Recommendation Report

EP/111/12

Description: Demolish 1 house (60 Sea Lane); partially demolish 1 house (45 The Ridings); construct 3 detached houses; alterations and extensions (45 The Ridings)

**Re: Planning application – 45 and 47 The Ridings and 60 and 62 Sea Lane,
 East Preston, Littlehampton, BN16 2TW**

scale AS SHOWN @ A1	checked GR
date AUGUST 2012	drawn WD
8217 / 106	A.

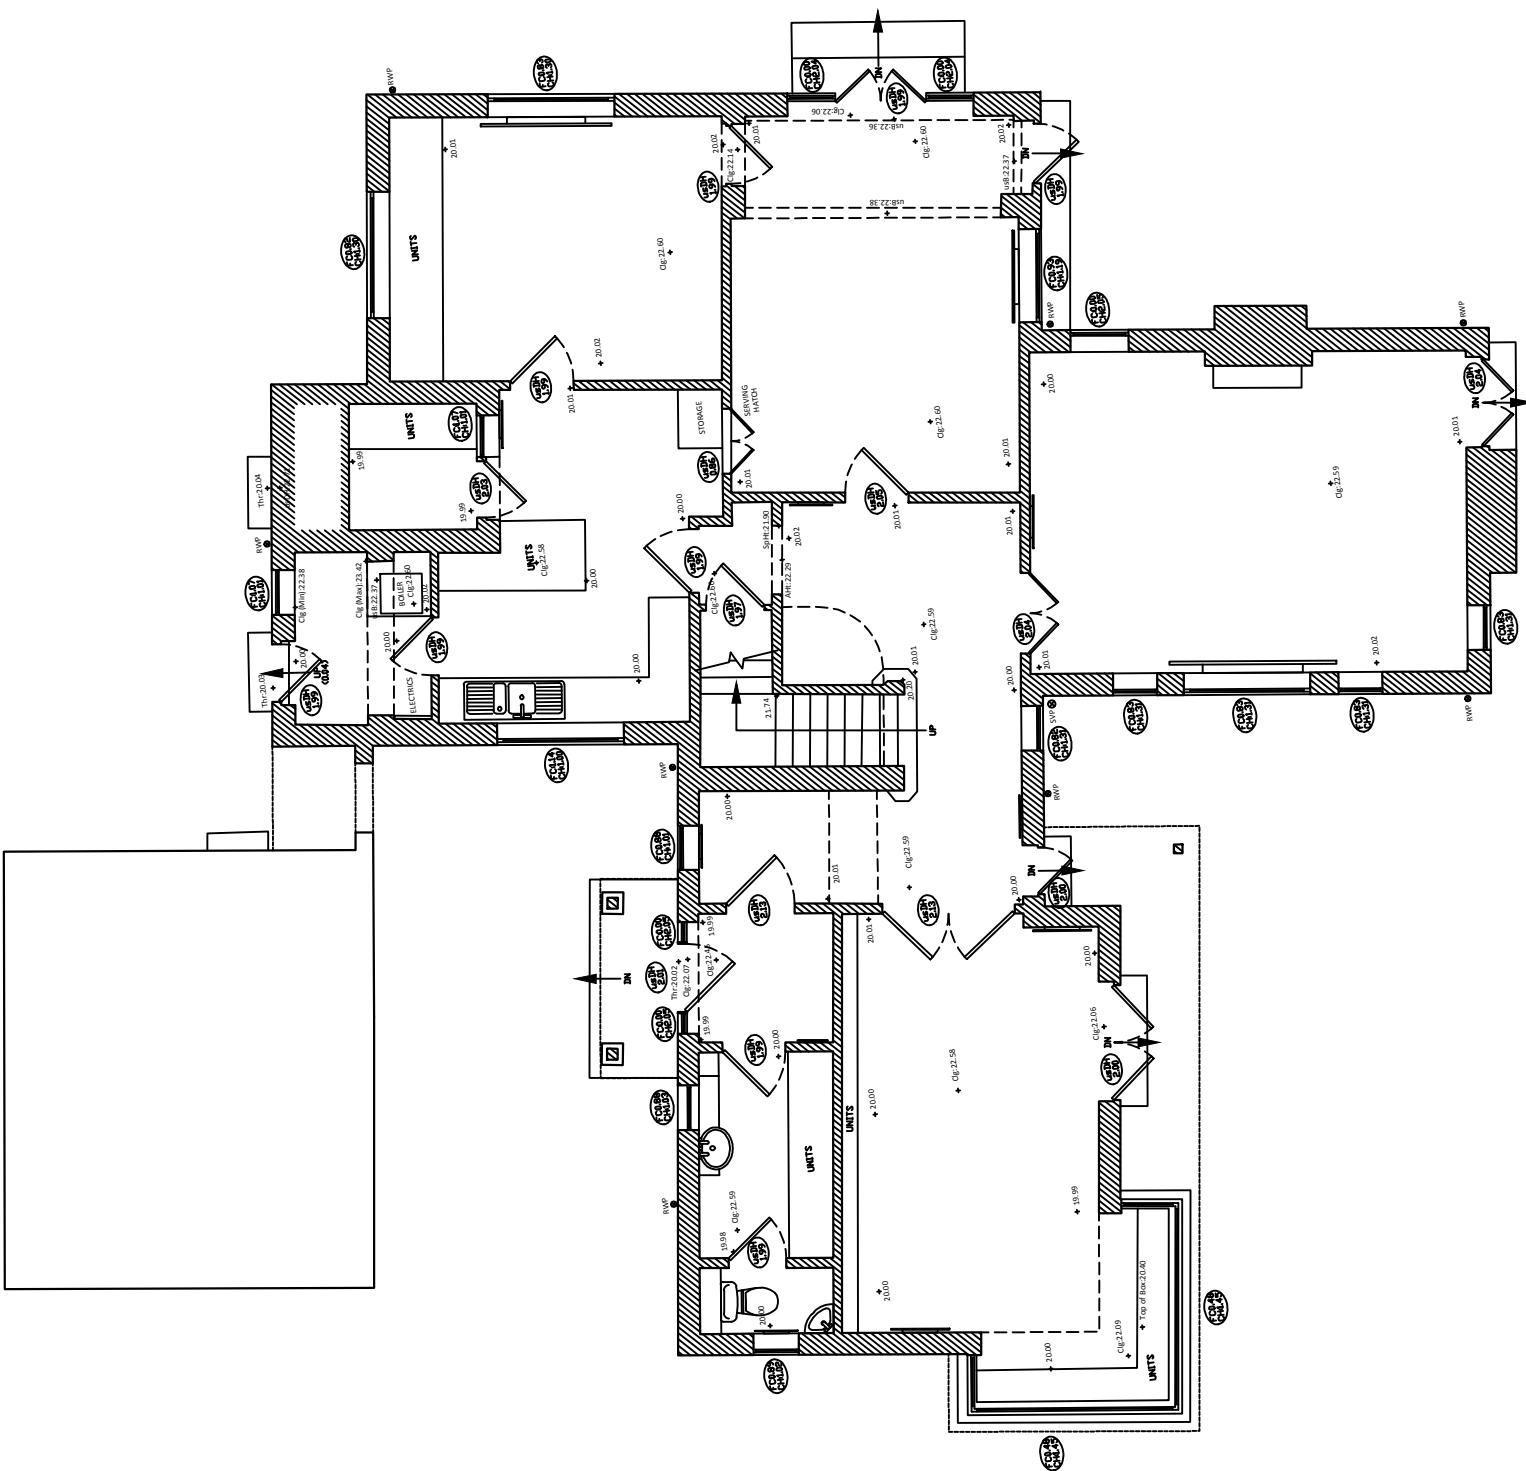
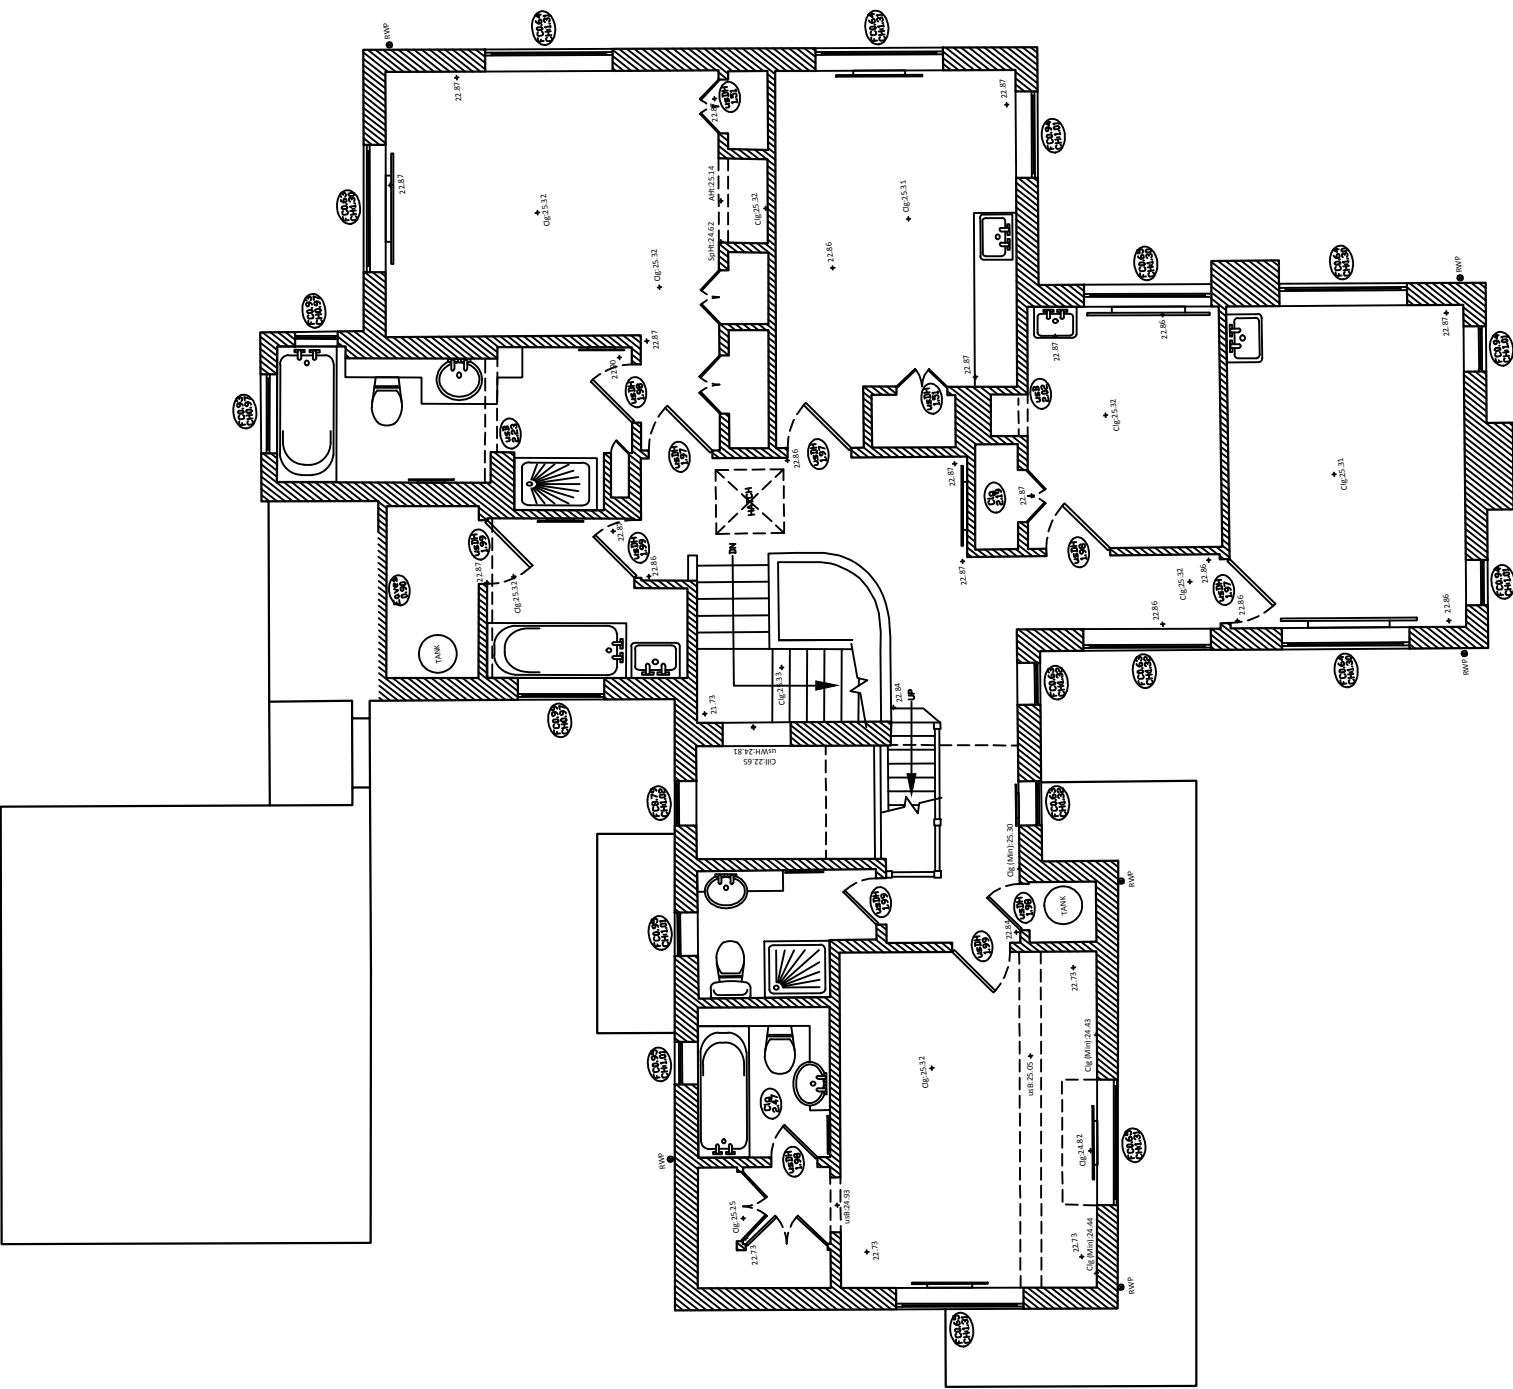
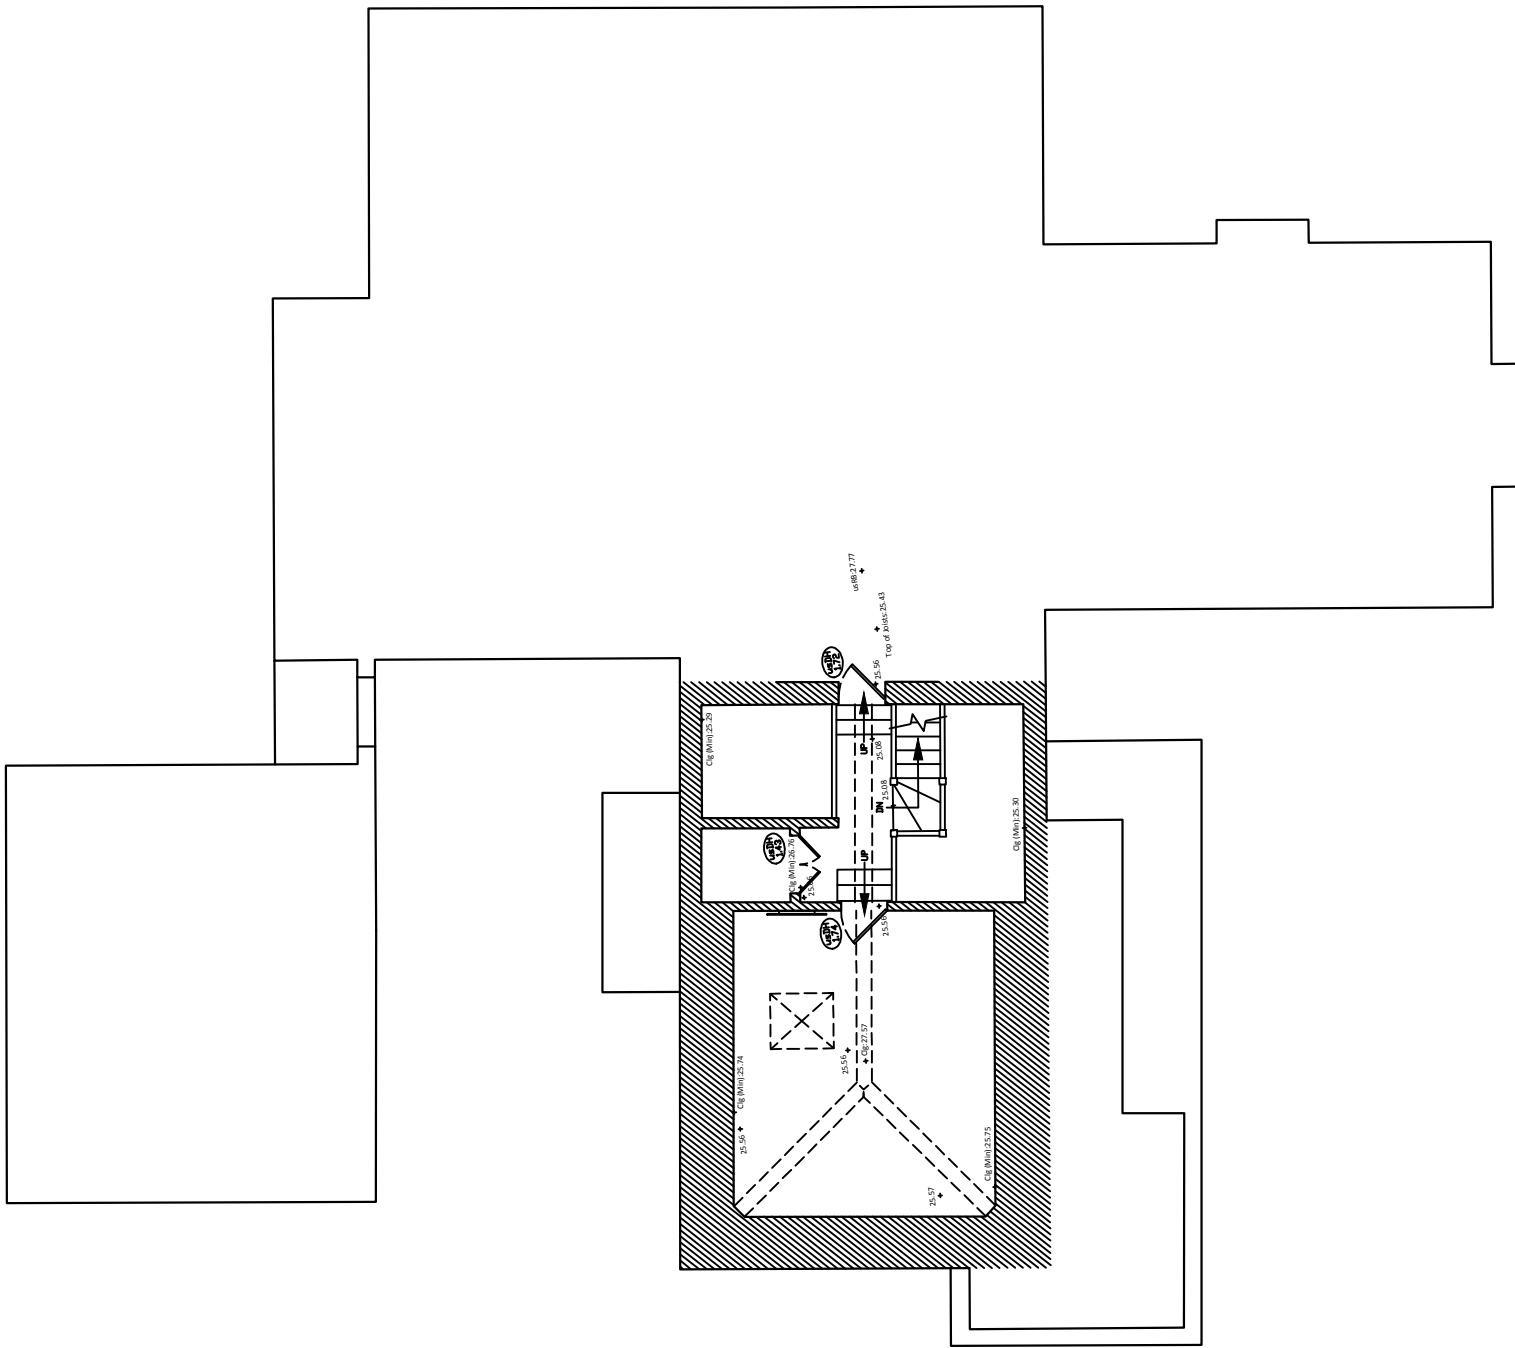
Without prejudice, I consider that reducing the overall ridge height would be beneficial to the appearance of the proposal and such an amendment can be accepted without generating a requirement for re-advertising. I have also noted that the submitted plans contain the note 'Do Not Scale' and I would request that this is amended to refer to 'except for planning purposes'.
